From: James Neave
Sent: 06 March 2014 15:52
To: Nat Slade; Peter Cleveland
Subject: WSCC/096/13/F - Ford Waste Treatment Facility - Further Information
Attachments: WSCC Acoustic Consultant.pdf; Environment Agency response.pdf; Public Health England response.pdf

PROPOSED DEVELOPMENT AND OPERATION OF A WASTE TREATMENT FACILITY NEW CIRCULAR TECHNOLOGY PARK (FORMER FORD BLOCKWORKS), FORD AIRFIELD INDUSTRIAL ESTATE, FORD, ARUNDEL, WEST SUSSEX, BN18 0HY

Review of a Noise Impact Assessment relating to a Proposed Waste Treatment Facility at Ford, Sussex

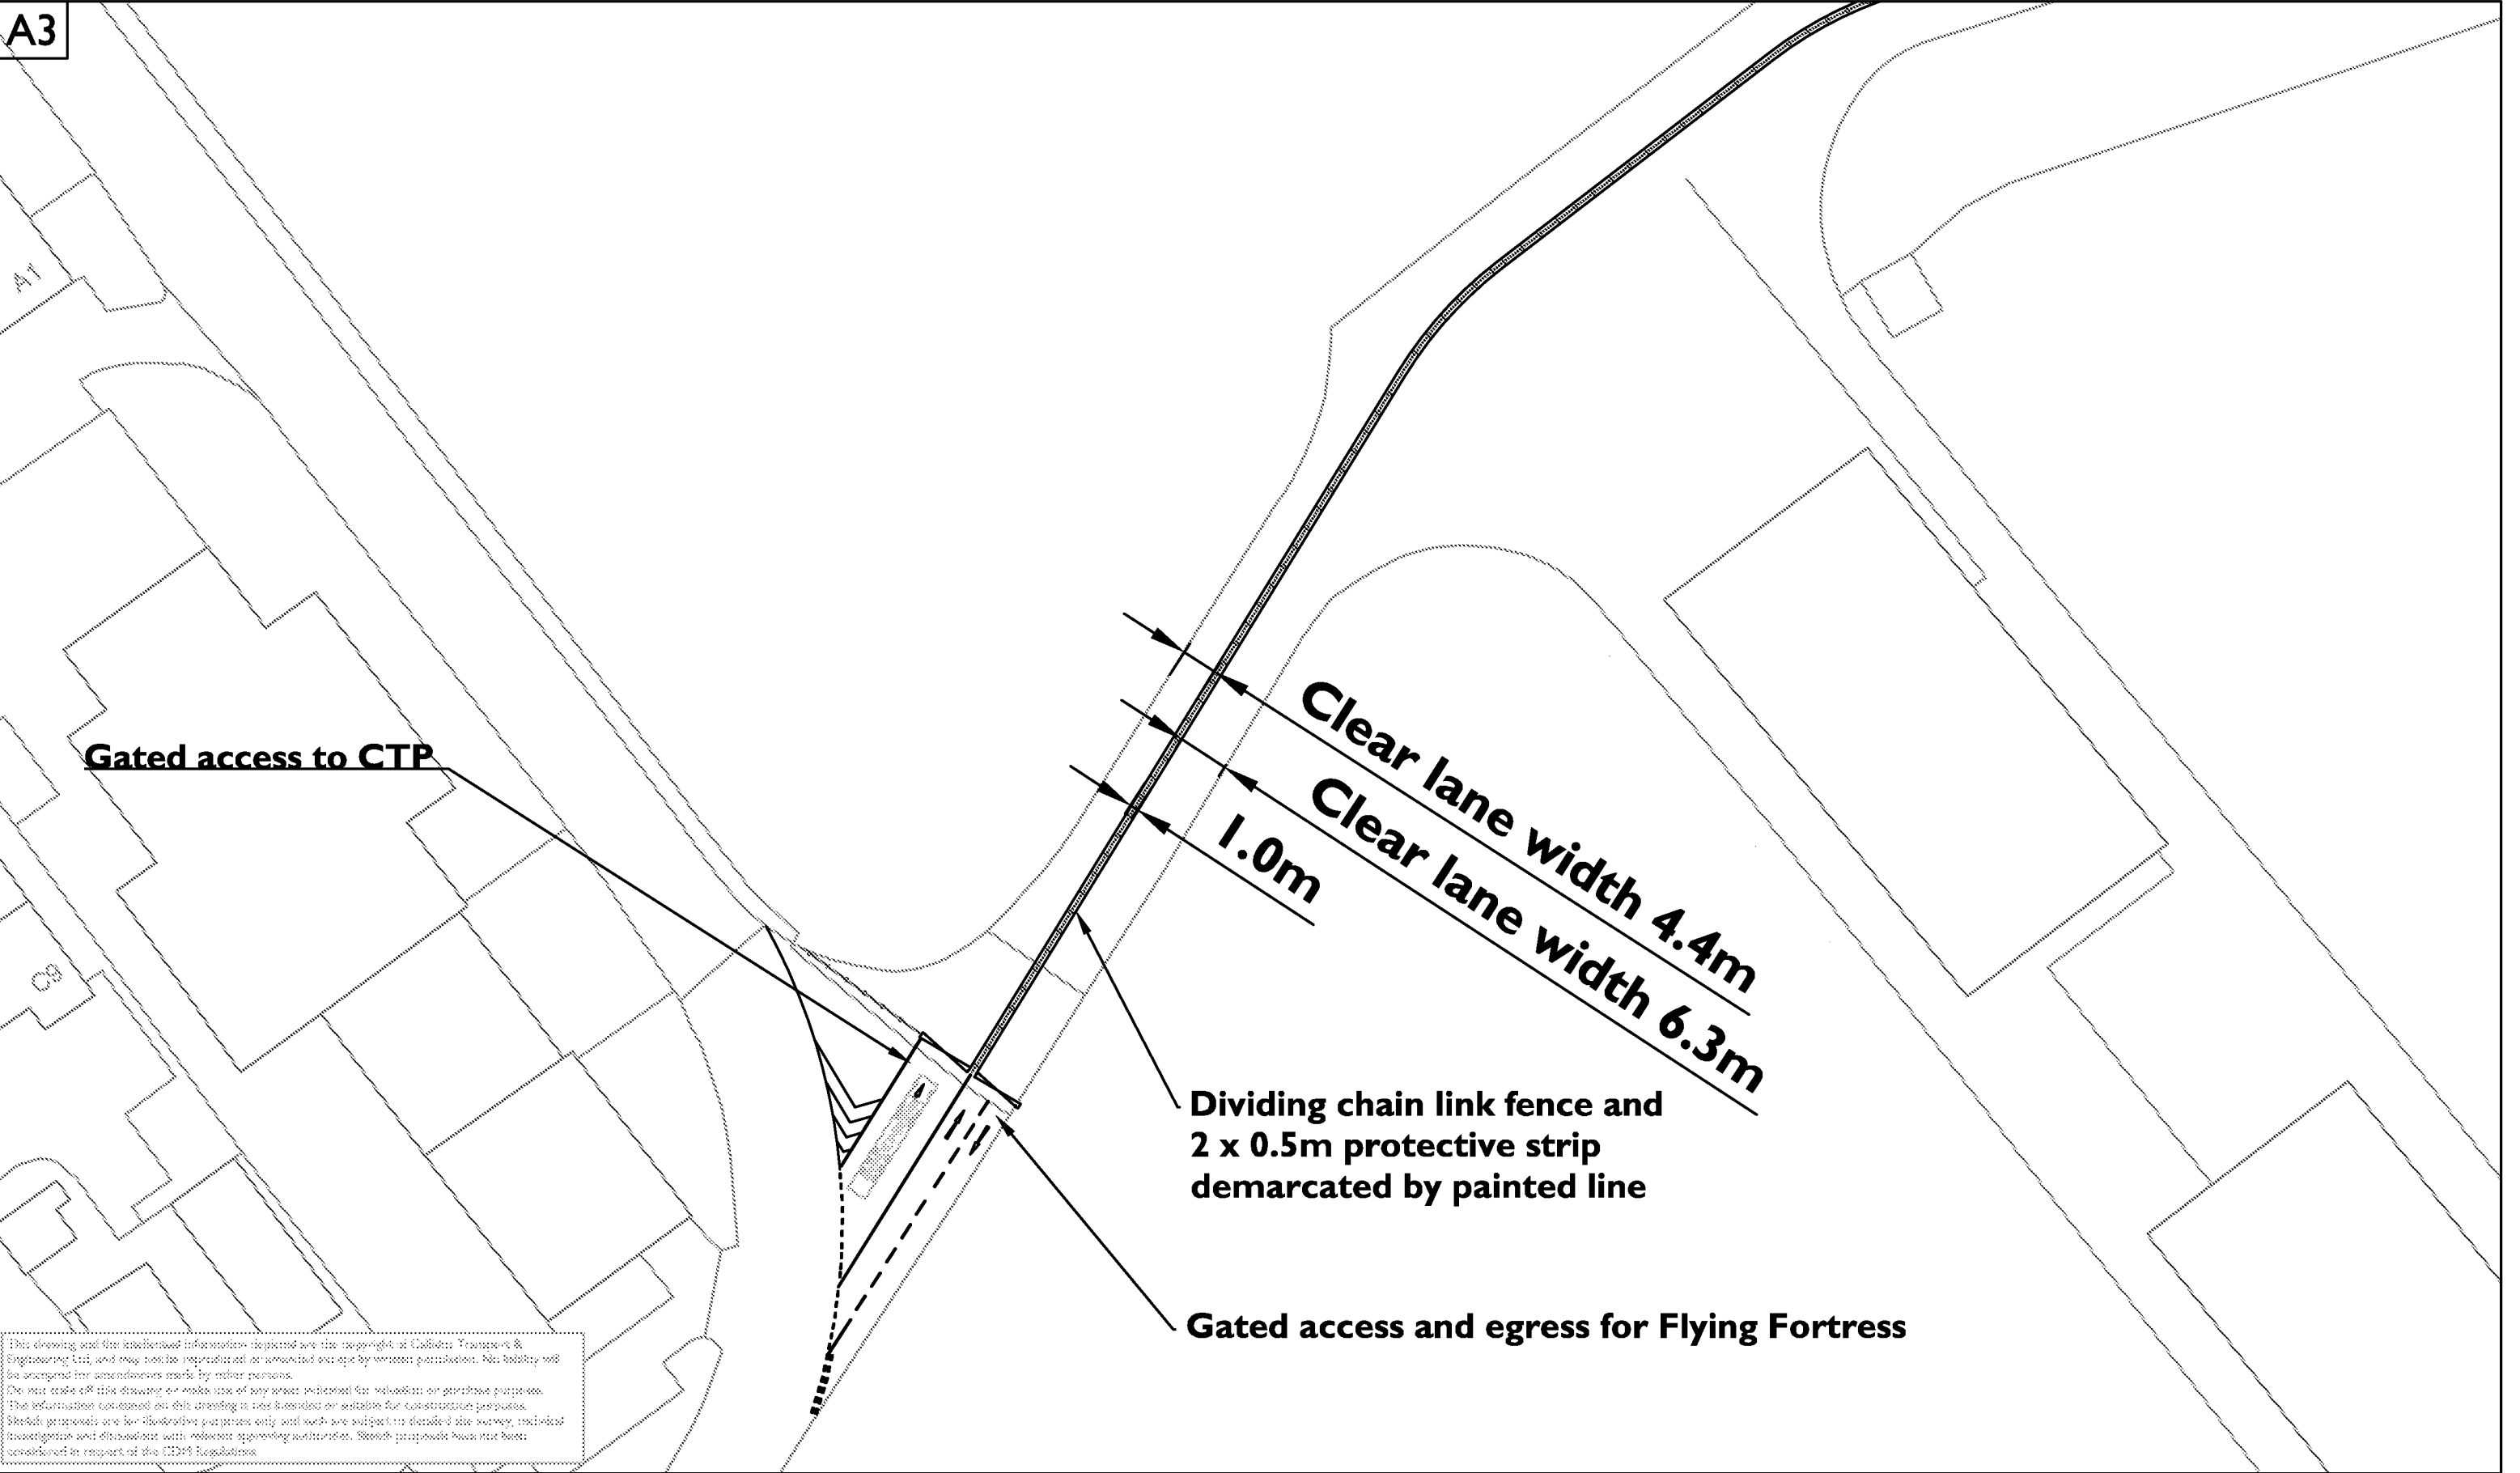
- Please also note the further info specifically addresses the stack height at paragraph 5.3.
- Please see appendix 4 (revised access layouts), this proposal seems to have a direct impact on the Flying Fortress Car-Park that seems not to have been laid out in accordance with ADC approved plans (F/1/04)
